From: [REDACTED]
Sent: 05 September 2019 18:37
To: Andrew Wood <Andrew.Wood@arun.gov.uk>
Subject: Re: 117, Elmer Road, Elmer - M/42/19

sheet 1 a of 4

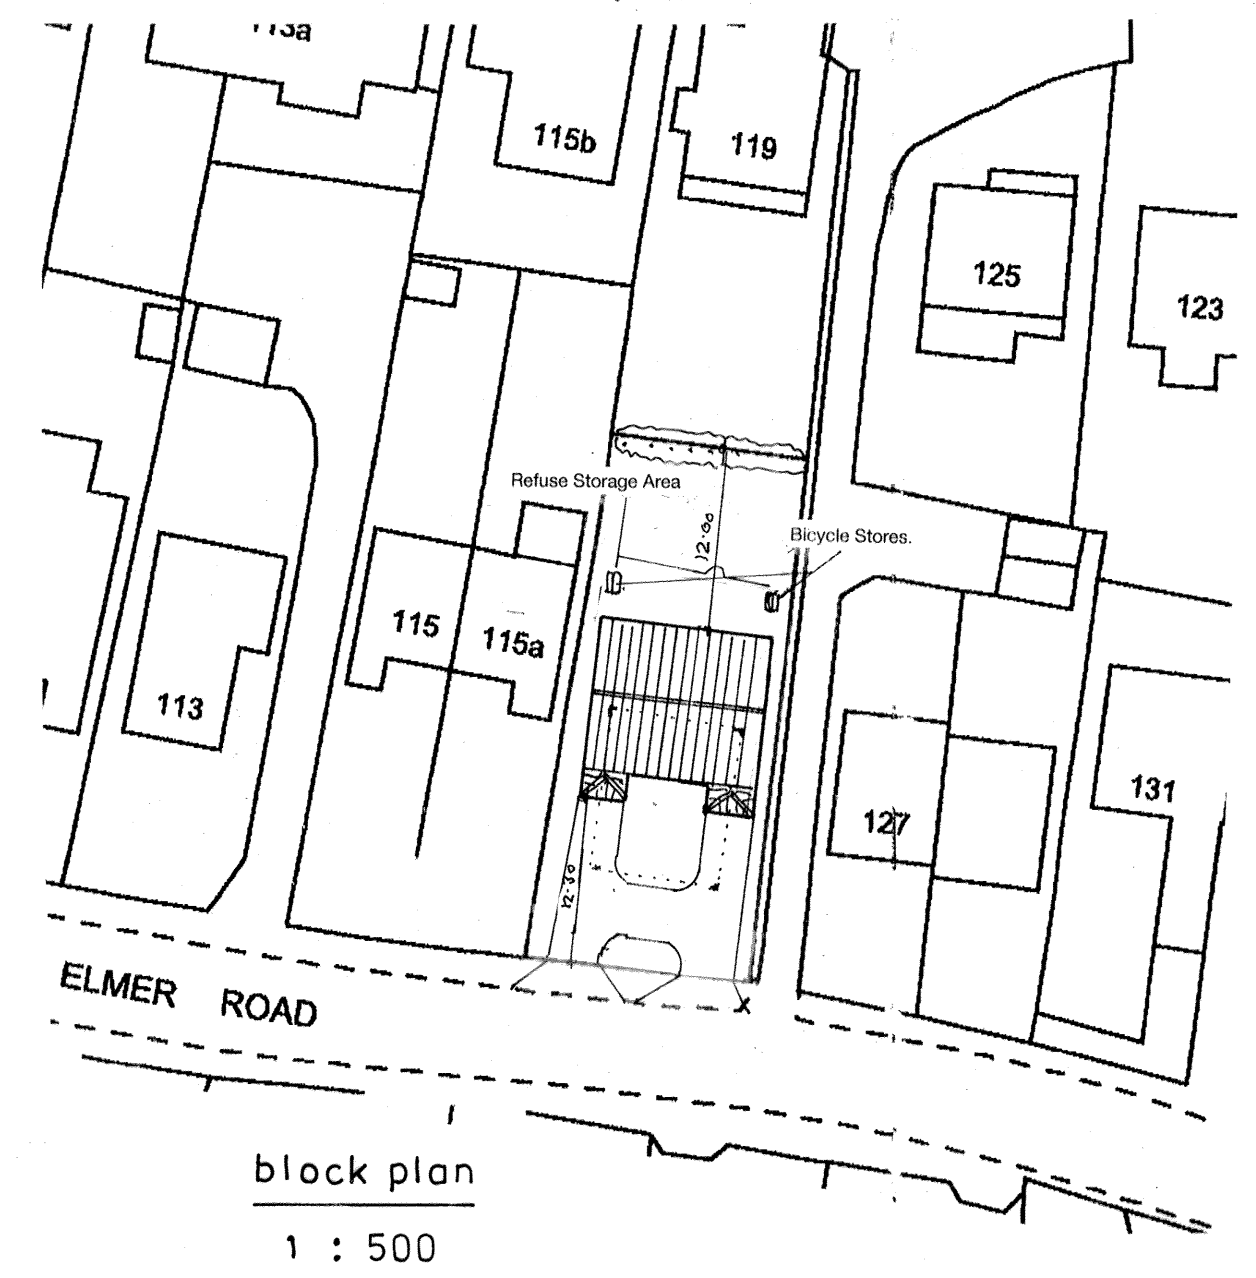
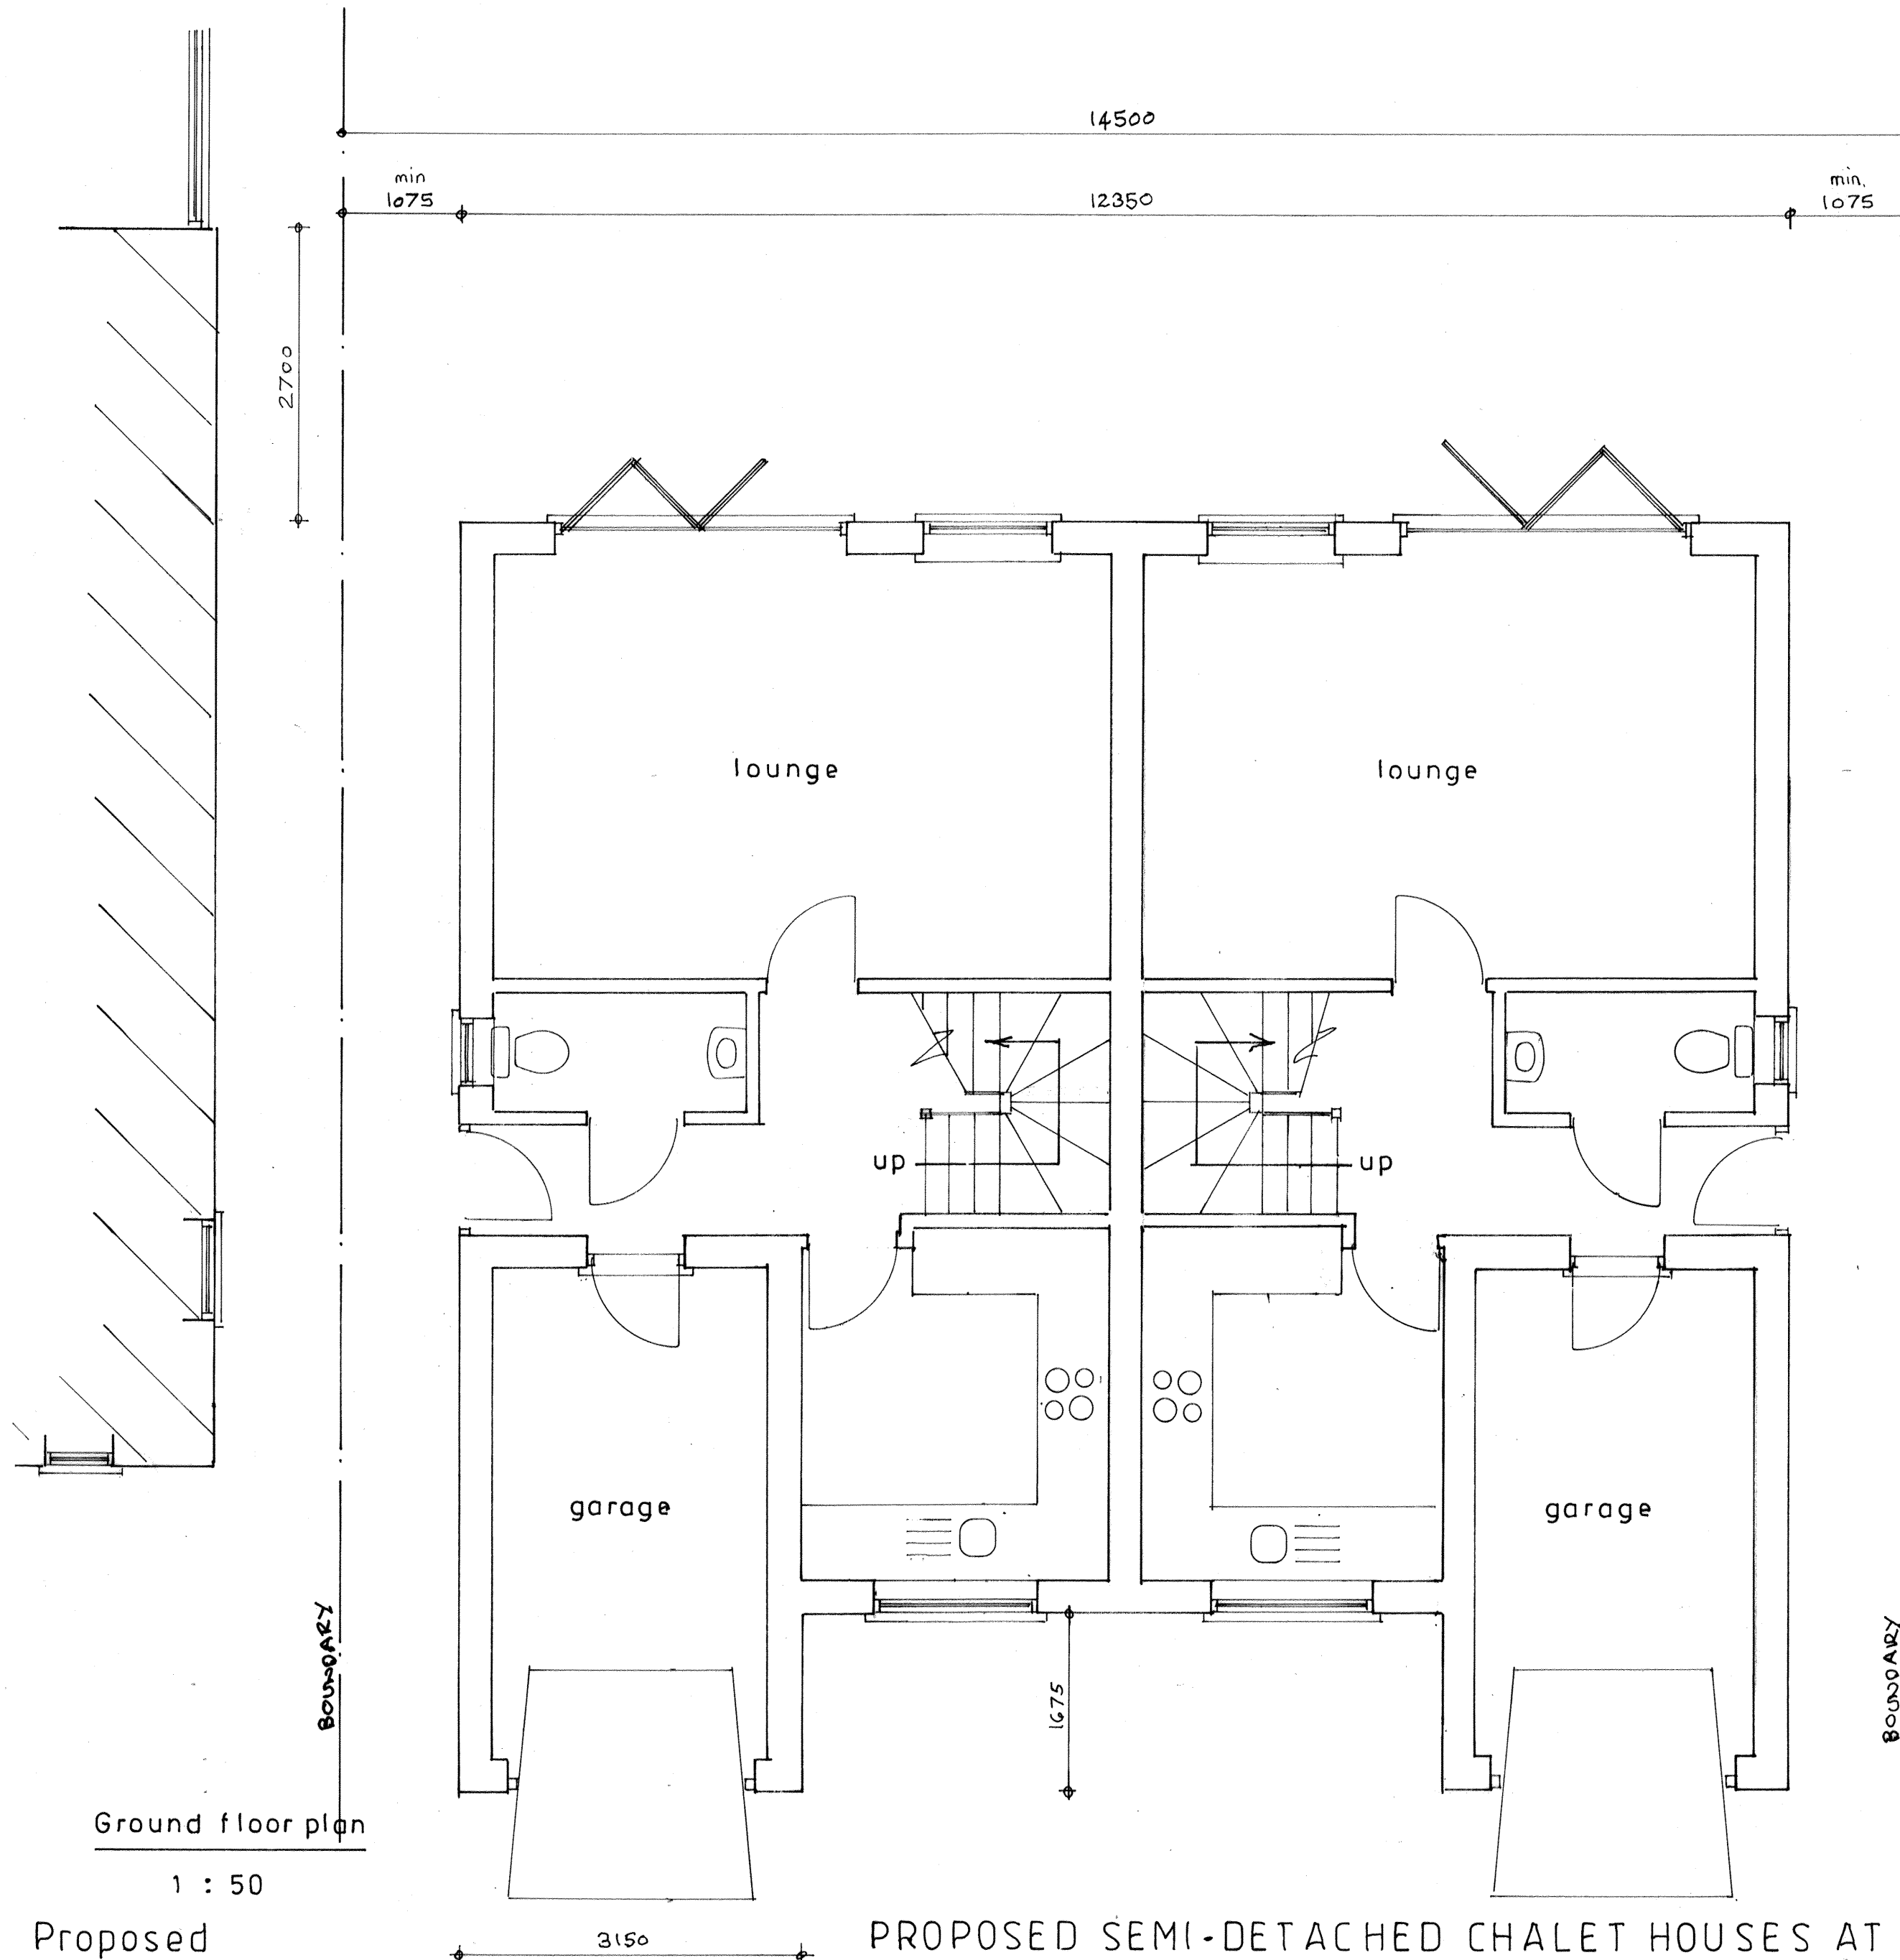
Please see attached highways comments and request for further information. Please provide information as requested.

The cycle stores are shown on the block plan on sheet 1a of 4.
